The Secretary,
An Coimisiún Pleanála,
64 Marlborough Street,
Dublin 1,
D01 V902
Case reference: PAX91.323780

Ballinlee Wind Farm – Individual Submission

Submitted by: Geoff Dooley
Address: Camas South, Bruff, County Limerick, V35 EH72

Date: 16th November, 2025

Figure 2-17: OSI Borrow Pit Locations

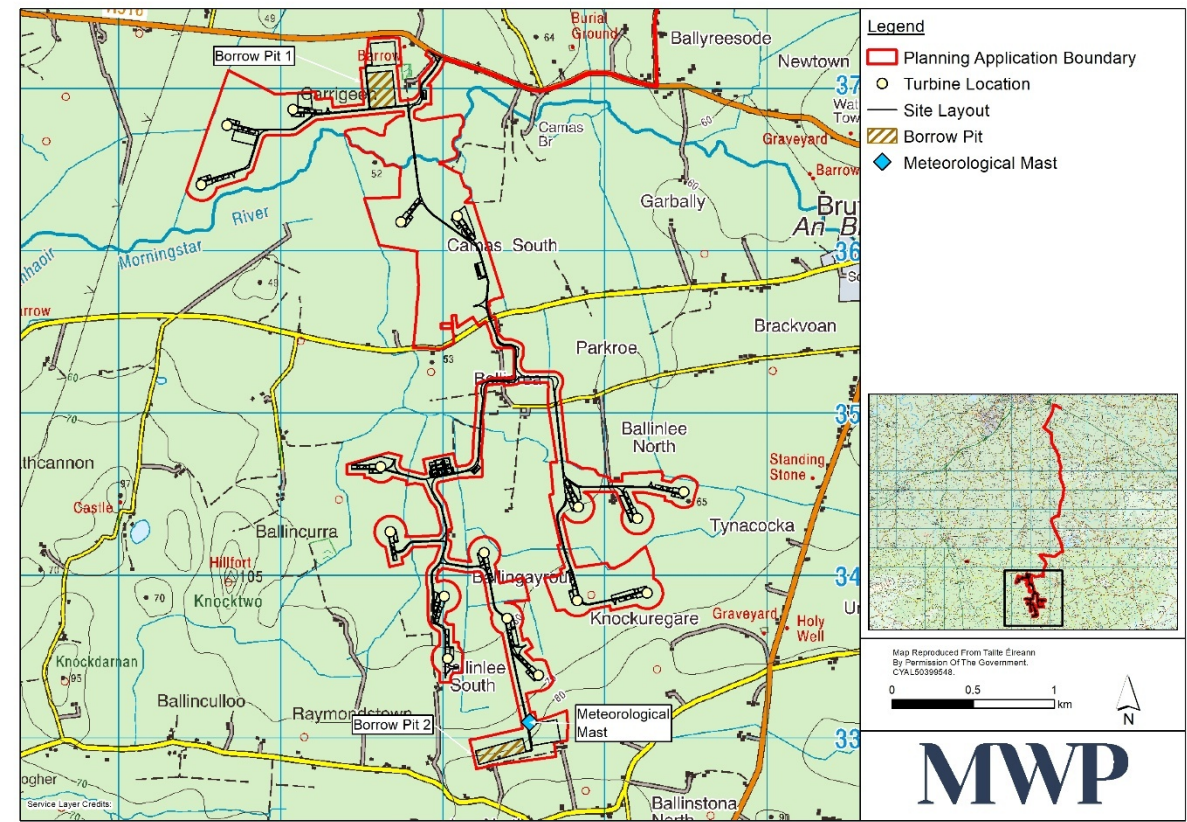
Chapter 8 of the EIAR (Land, Soils and Geology) and the trial pit data in Appendices 8A and 8B confirm groundwater was encountered at depths from 1m in August 2024 and February 2025, proving that a high water table is not just a seasonal variable. Yet large-scale excavation is proposed for turbine bases and two on-site quarries (or what the EIAR refers to as borrow pits)

The developer's claim that on-site borrow pits will reduce HGV movements and environmental footprint is unsubstantiated, based on very limited trial pit data. The data they do provide contradicts their claims of aggregate availability. See fig below.

Figure 8-15: Trial Pit Positions

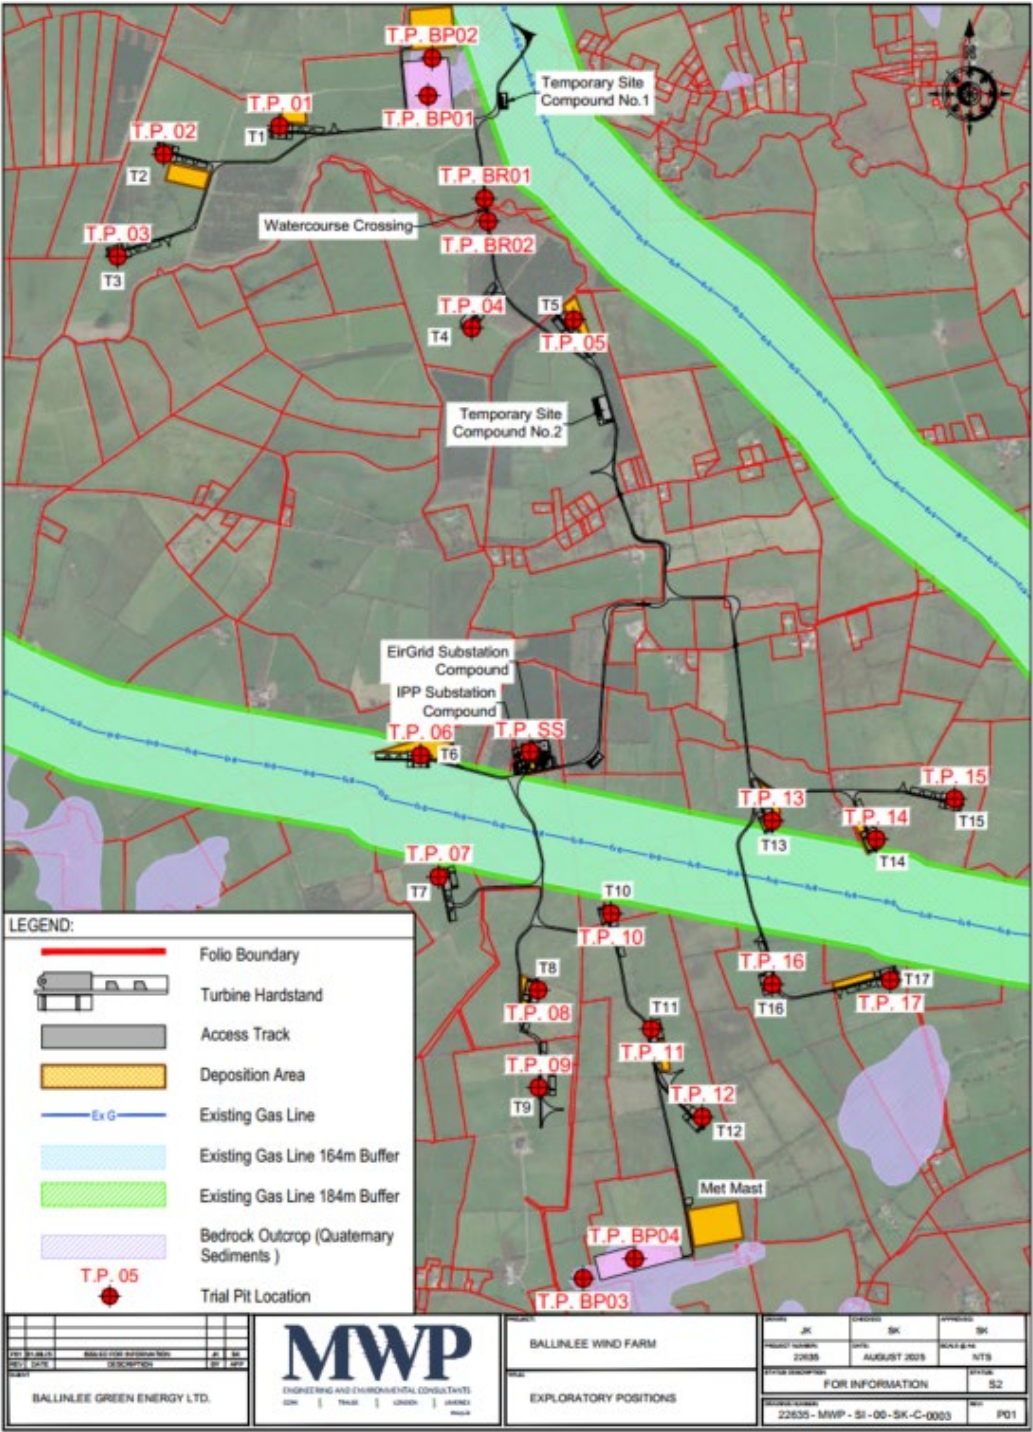
This trial pit exploration method, using a small mini digger (Yanmar Universal Vio 50), is not useful for deep exploration to bedrock and is incapable of taking bedrock samples or going past the bedrock.

Across all the trial pits, the predominant material was a shallow topsoil, followed by heavy brown clay and silt mixed with cobbles. This is very unlikely to be the type of aggregate the developer requires. And the developer has no evidence that it is a suitable load-bearing material because they didn't get it tested. Therefore, the EIAR's claims about the availability of on-site material are unsubstantiated. The implications are that it is impossible to have confidence in the other claims made in the EIAR around traffic movement, the import/export of spoils and aggregate, traffic impacts, and hydrogeological impacts.

If there isn't a suitable on-site aggregate via the on-site quarries they propose to create during the development phase, thousands of additional truck movements will occur, invalidating key sections of the EIAR's alternatives and traffic analyses.
